Application Reference: 2025/0319

Location: 12 Guildford Road, Royston, Barnsley, S71 4HU.

This application seeks planning permission for the erection of a two-storey side extension.

GROUND FLOOR PLAN 1:50

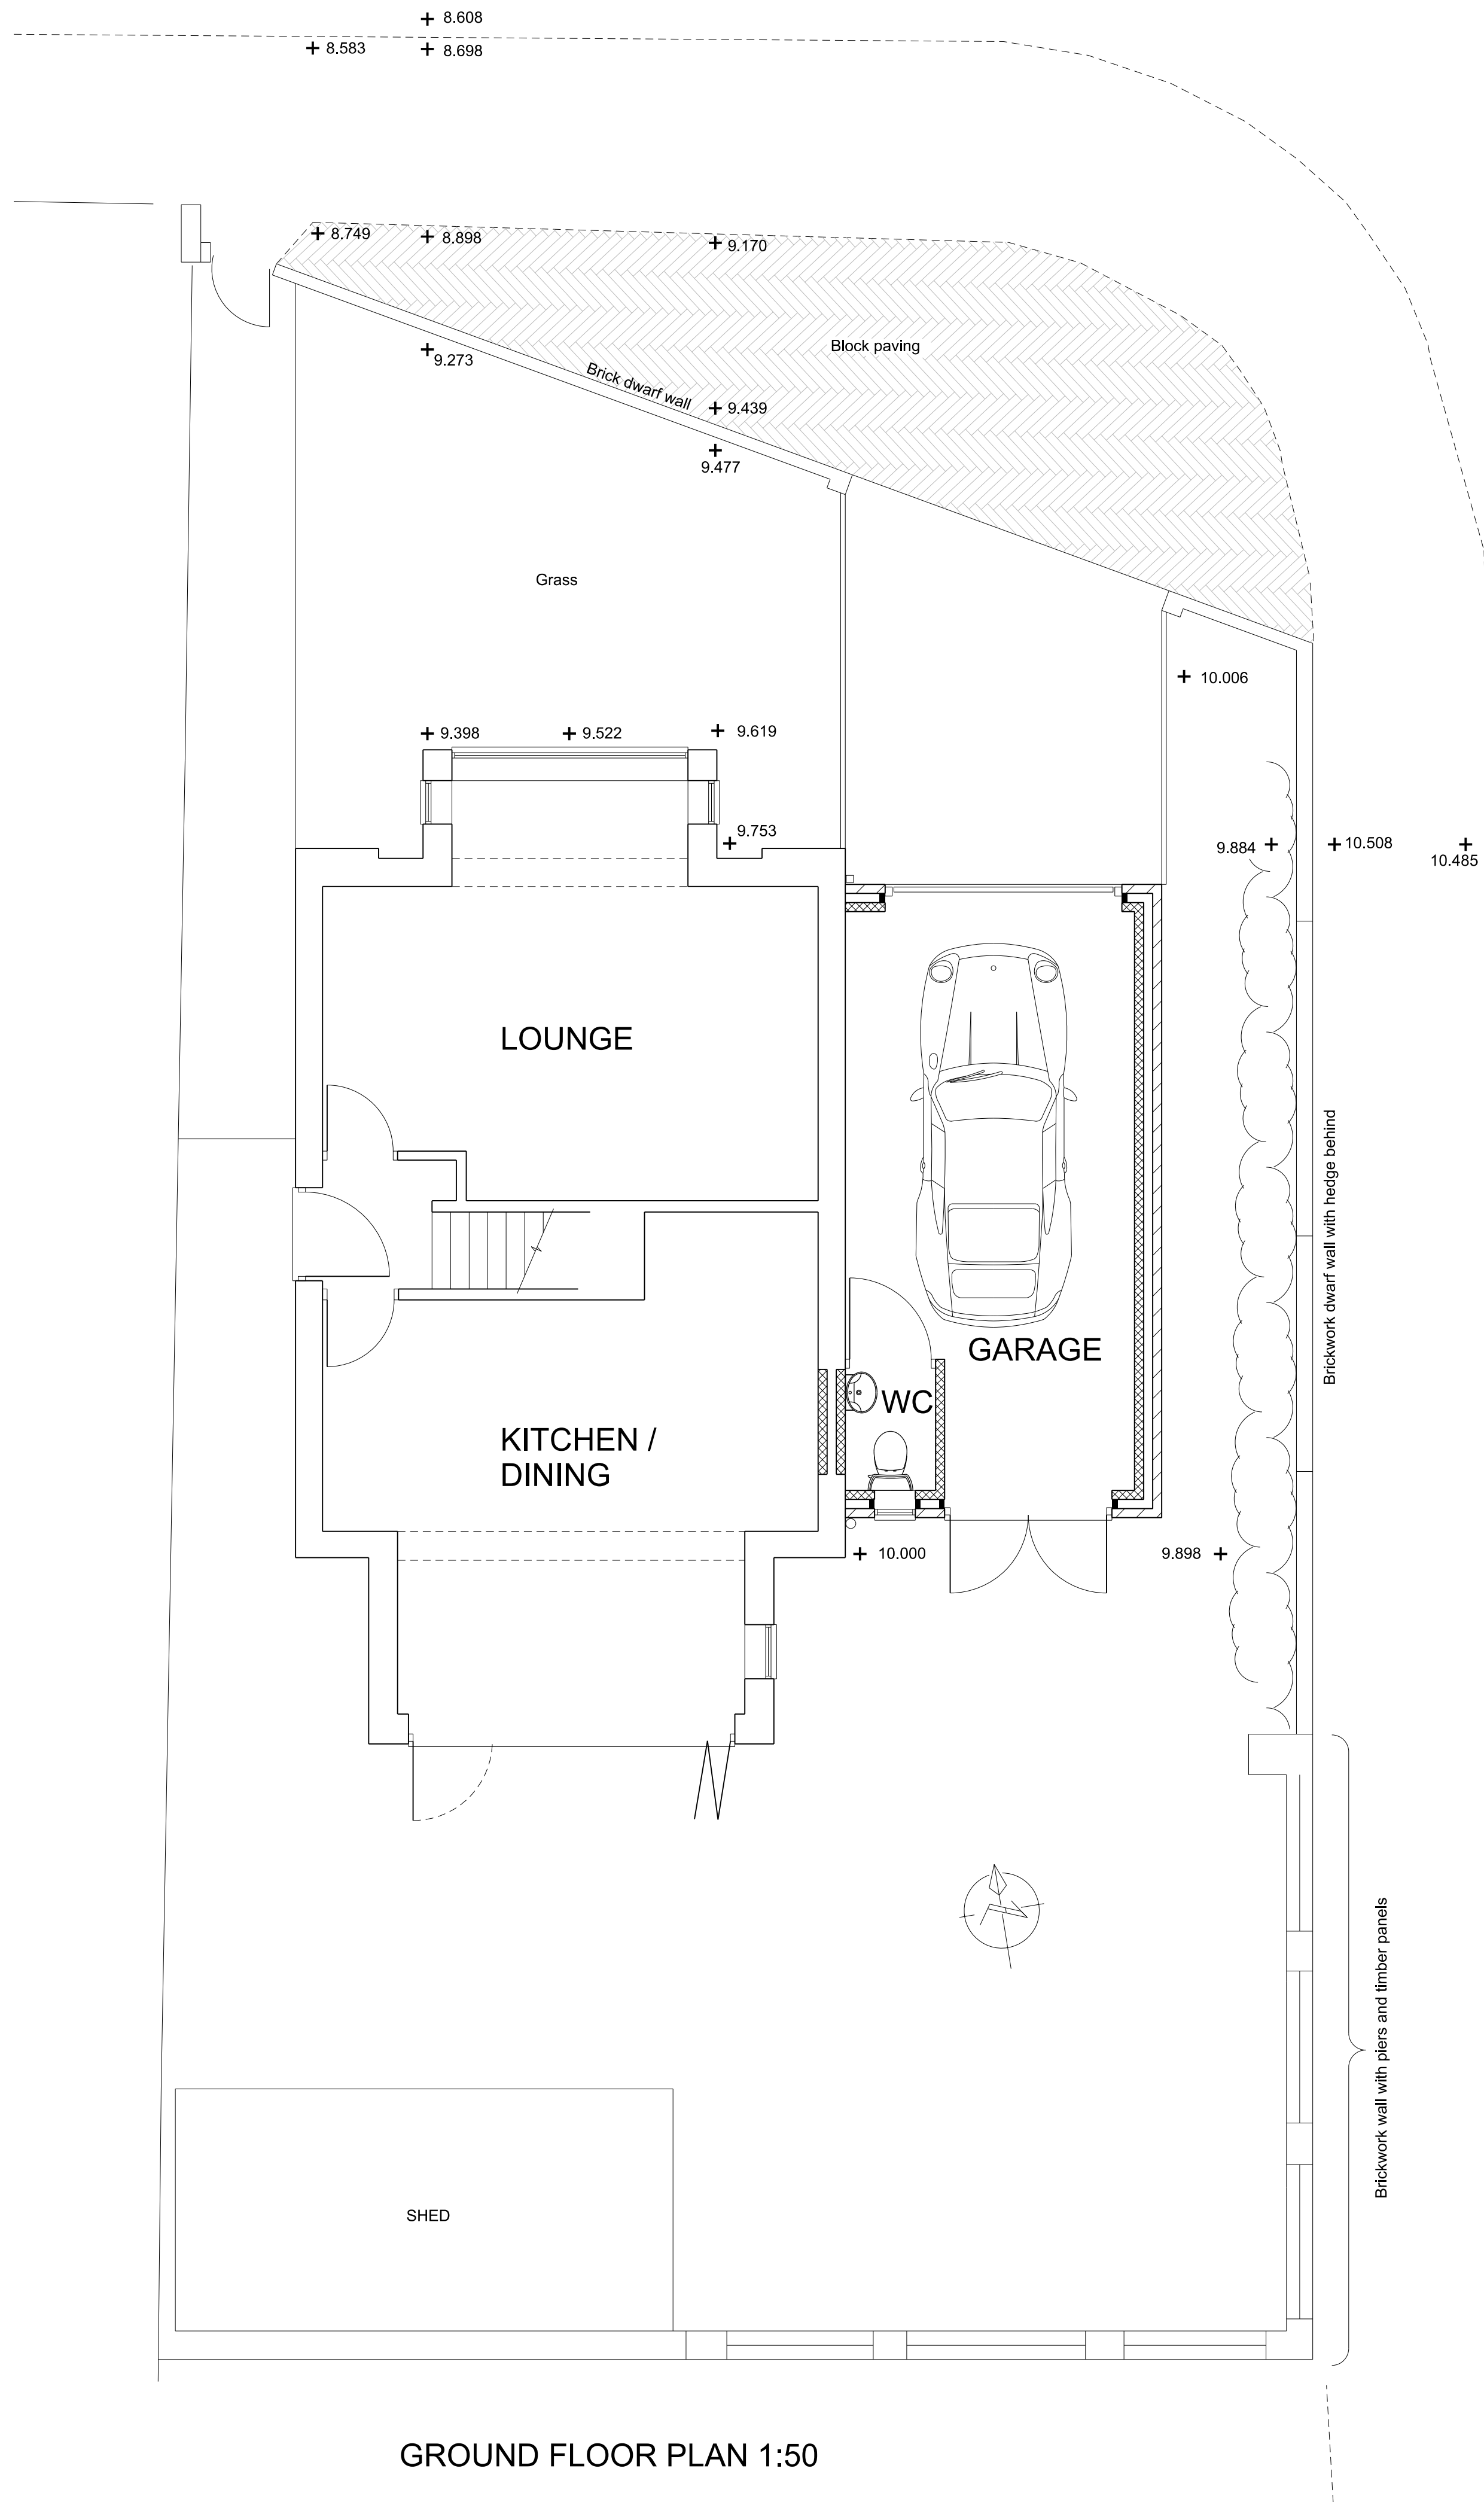
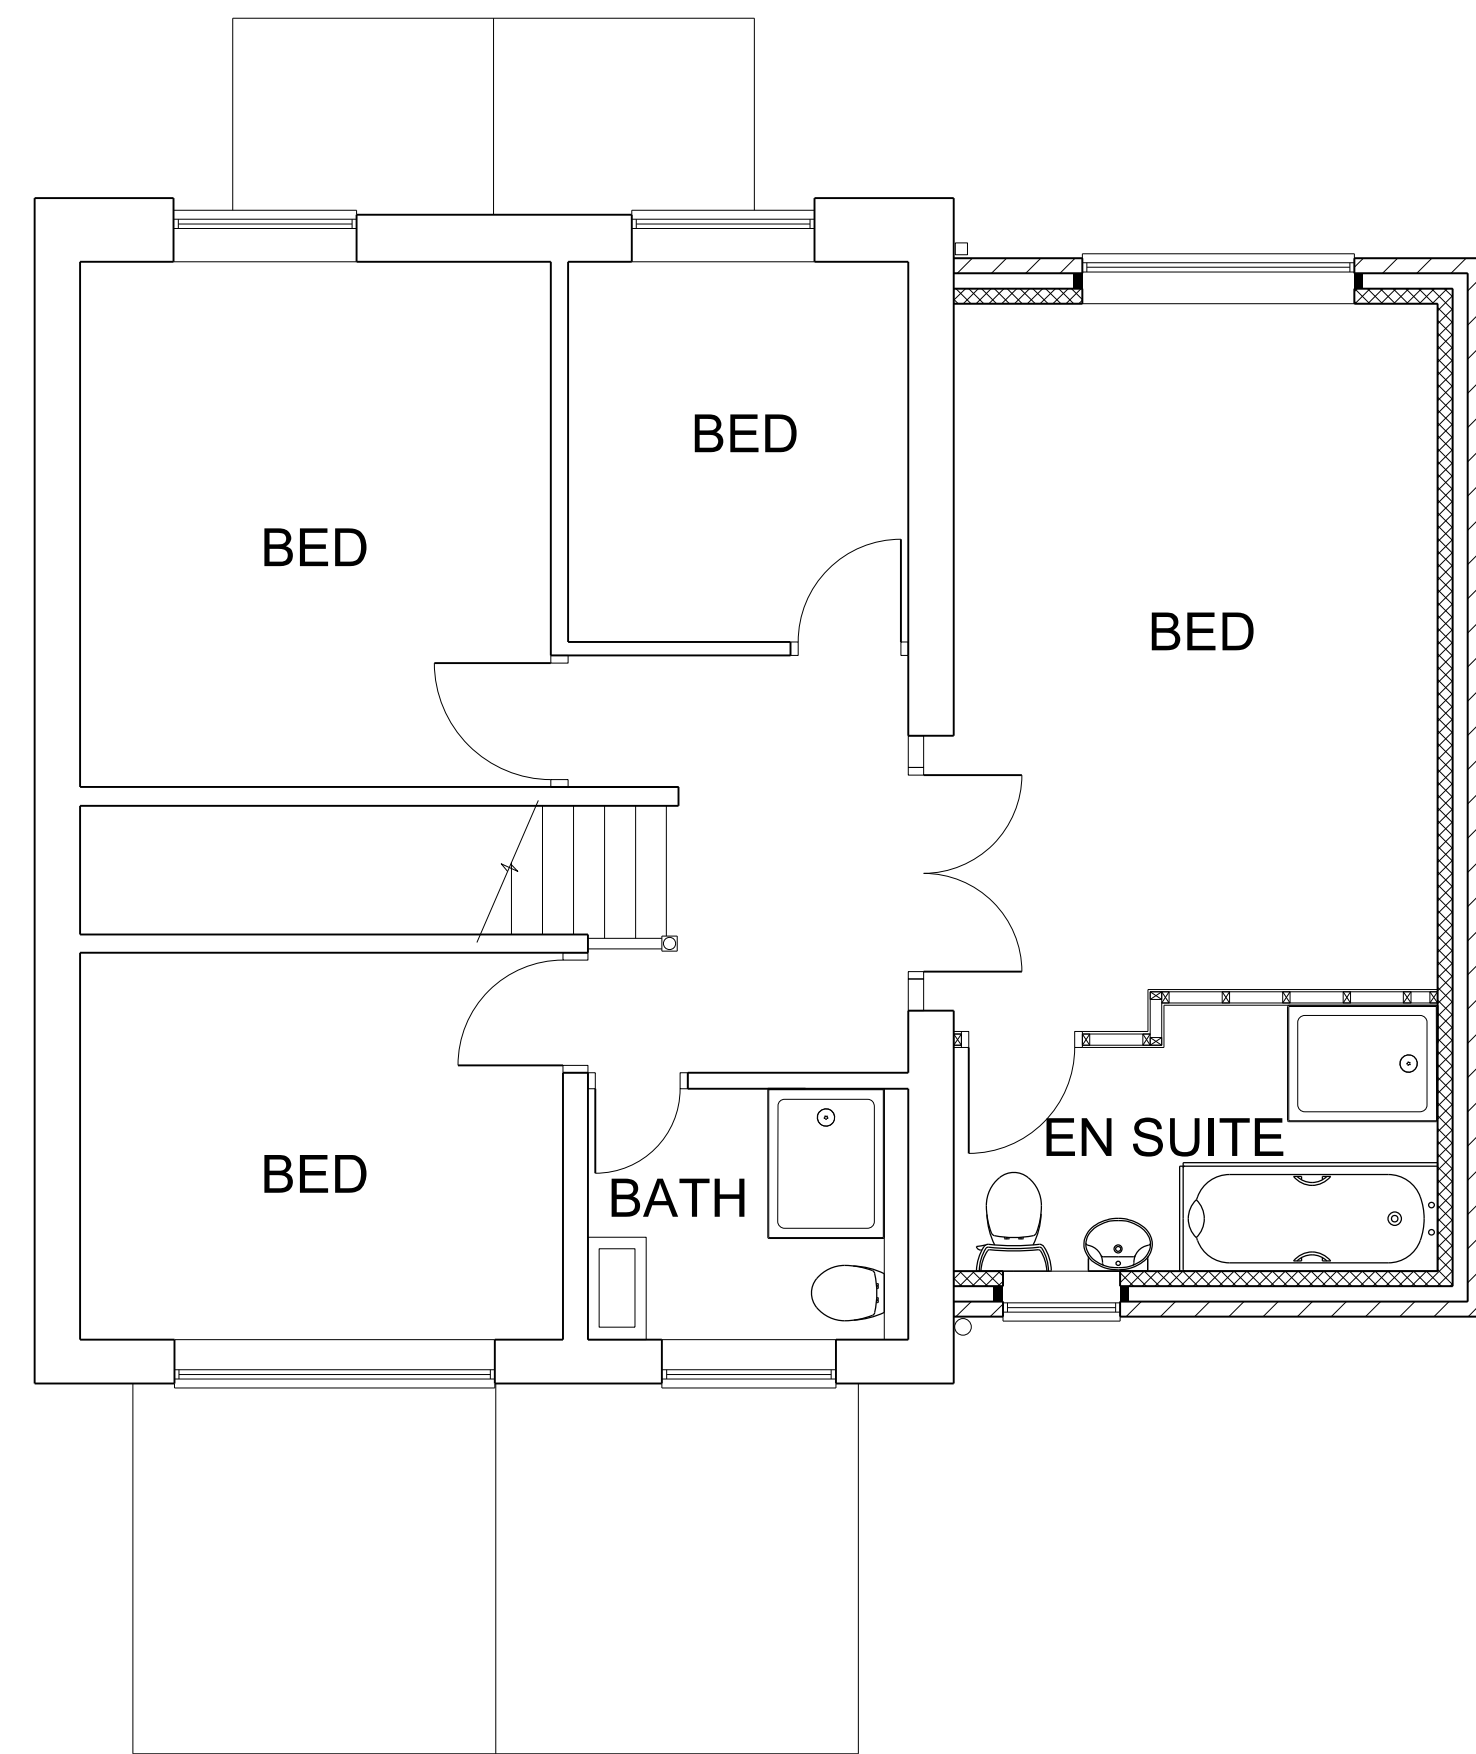
Furthermore, the integral garage would fall short of the minimum internal spacing standards set out by paragraph B.1.1.23 within the SYRDG, which states best practice suggests the internal floor area for car spaces (garages or car ports) should be 3 x 6.5 metres. The proposed garage would measure approximately 3.2 metres x 6.4 metres. However, because of the inclusion of a WC within the garage the useable space for parking is greatly reduced.

BLOCK PLAN 1:200

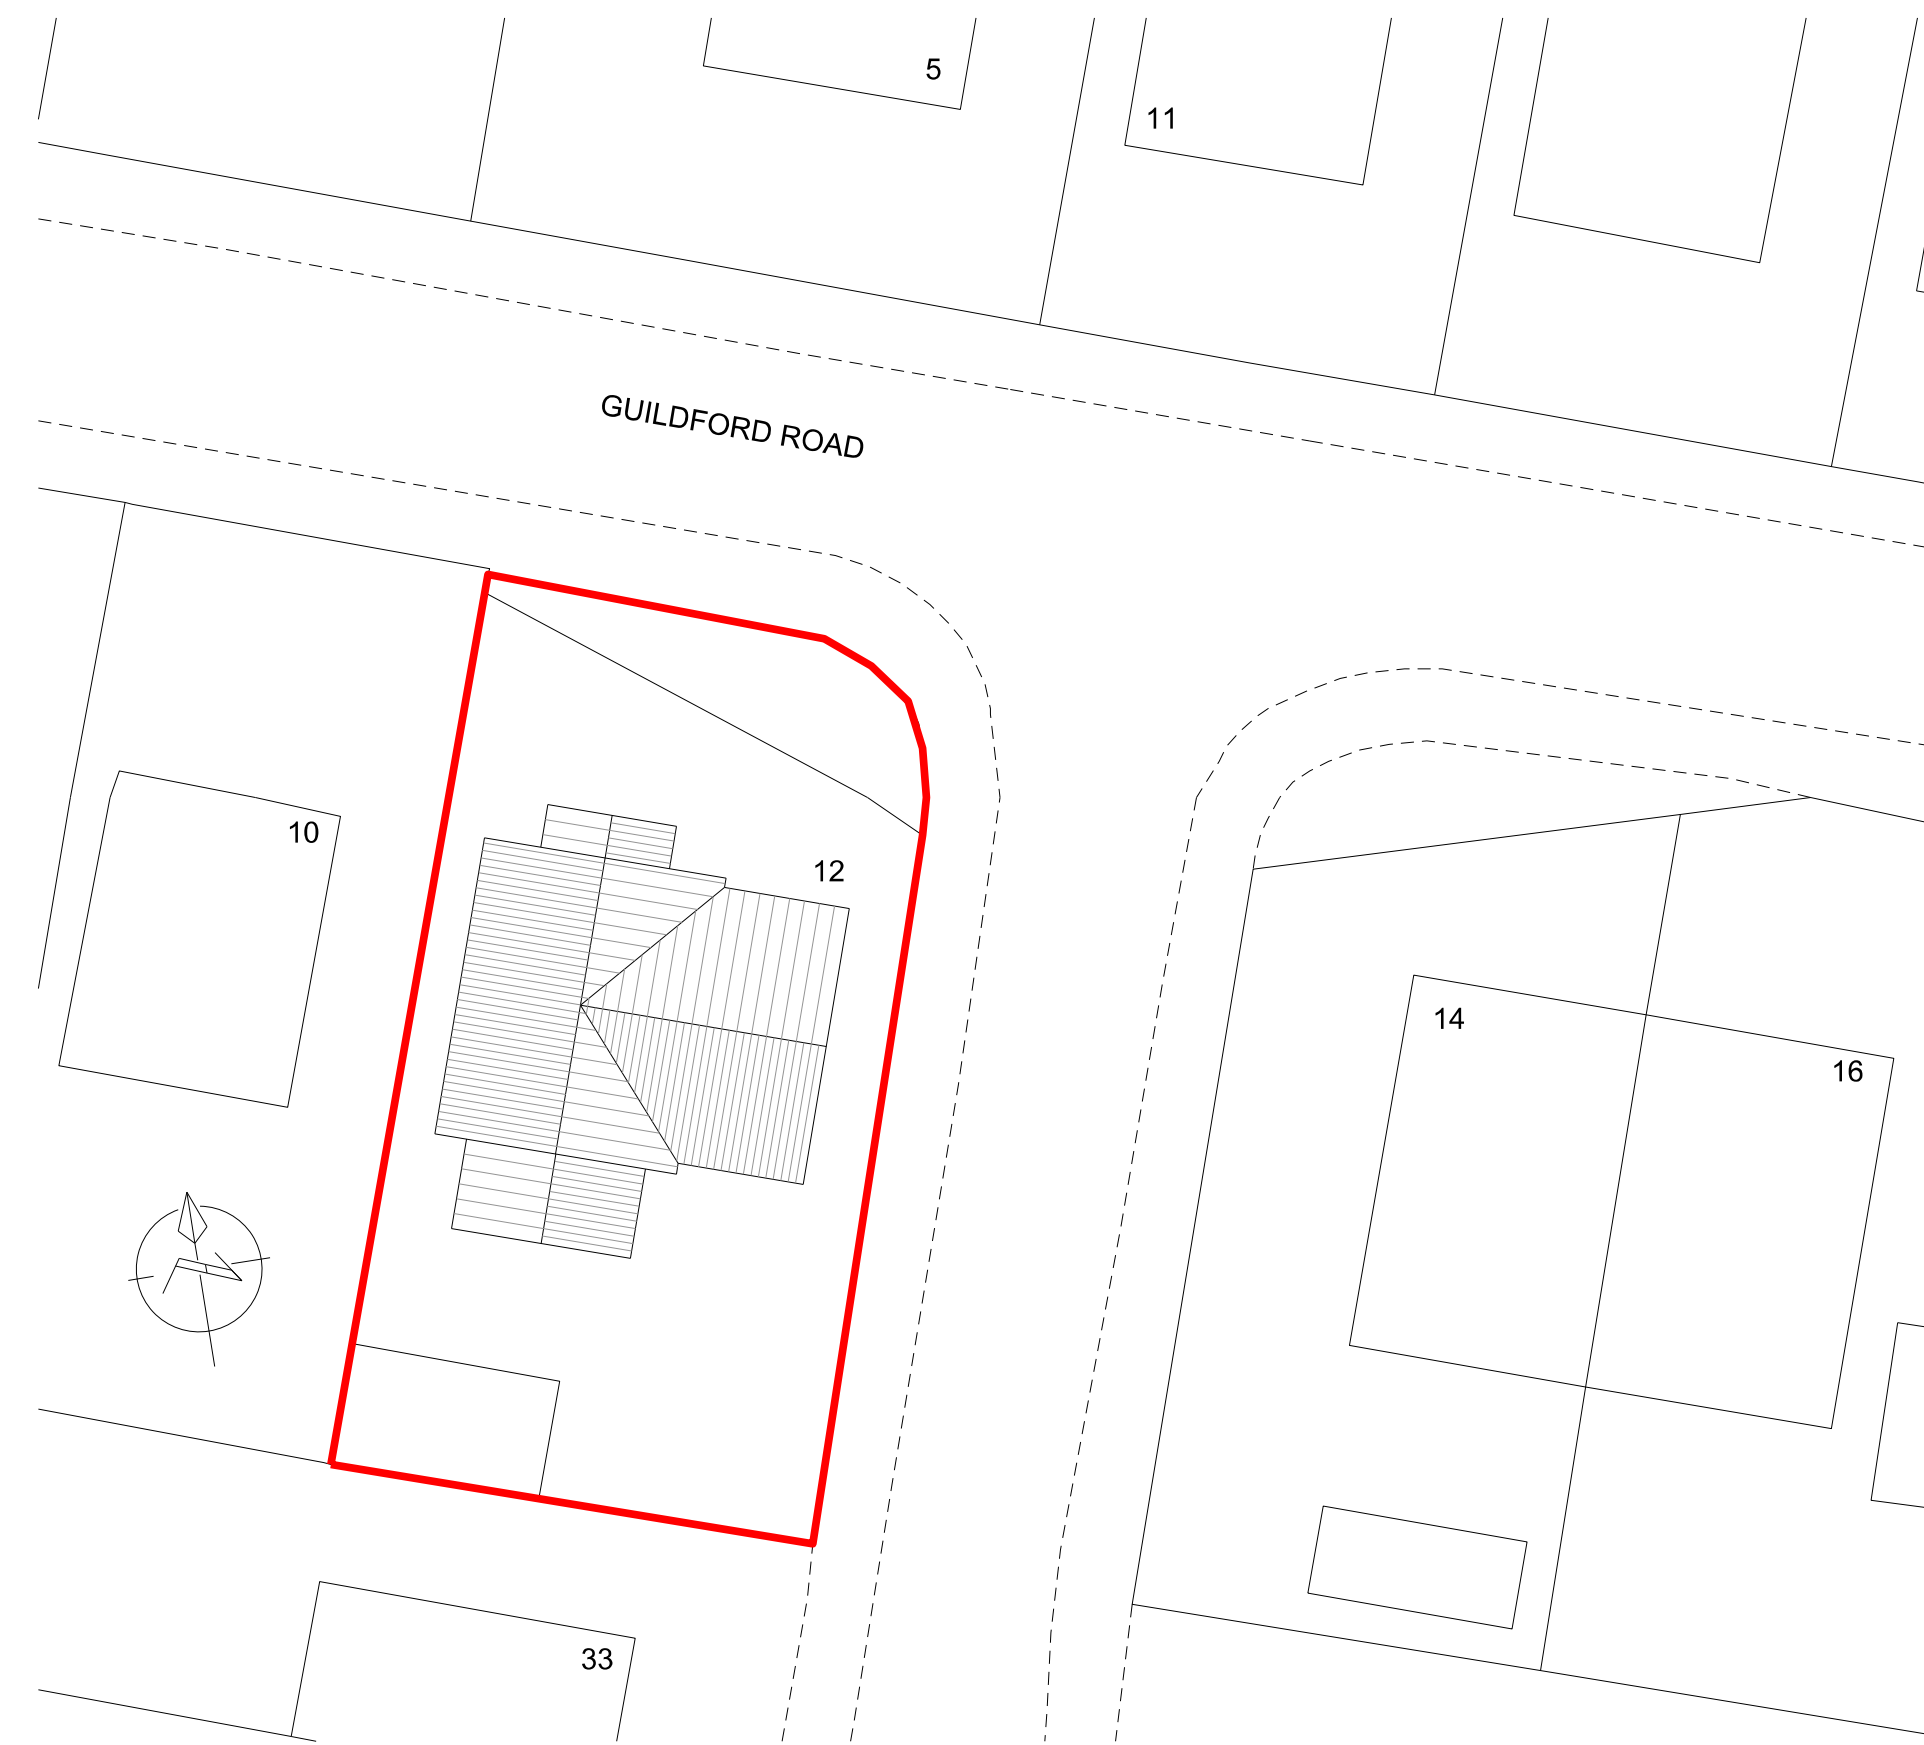
This application relates to a modest-sized corner plot located at the junction of Guildford Road with Buckingham Way and in an area that is principally residential. The proposal includes the formation of a new access and driveway to the north within the development site. It is noted that historic Google Street View imagery shows that a previous access to the development site off Buckingham Way has been removed, leaving the property without any formal off-street parking provision. An area of raised paving on the public footpath appears to be used for parking provision to the north. The site boundary is set behind this area which suggests it was designed to provide adequate visibility splays and sight lines at the junction of Guildford Road with Buckingham Way.

Highways Development Control were consulted, who stated that there were significant concerns in terms of highway safety because of the proposed access. The position of the proposed access would be directly adjacent to the junction with Buckingham Way and will fall within the radii of the junctions. The introduction of the access in this location could result in conflicting manoeuvres with road users when accessing and egressing the driveway. The length of the driveway also appears substandard. The minimum required driveway length is 6 metres, or 5.5 metres where a roller shutter door is used. A driveway length less than the minimum standards could result in vehicles overhanging the footway and causing an obstruction to pedestrians or restricting visibility for other road users. In addition, as the proposal includes an additional bedroom, increasing the existing provision from 3-bedrooms to a 4-bedroom dwelling, there is the potential for the associated parking demand to increase, and as per the Parking SPD, a minimum of 2 off-street parking spaces would be required to serve a dwelling

of 3-bedrooms or more. Consequently, an objection was raised from a highway's perspective. The LPA has no reason to disagree with the concerns raised in this instance.
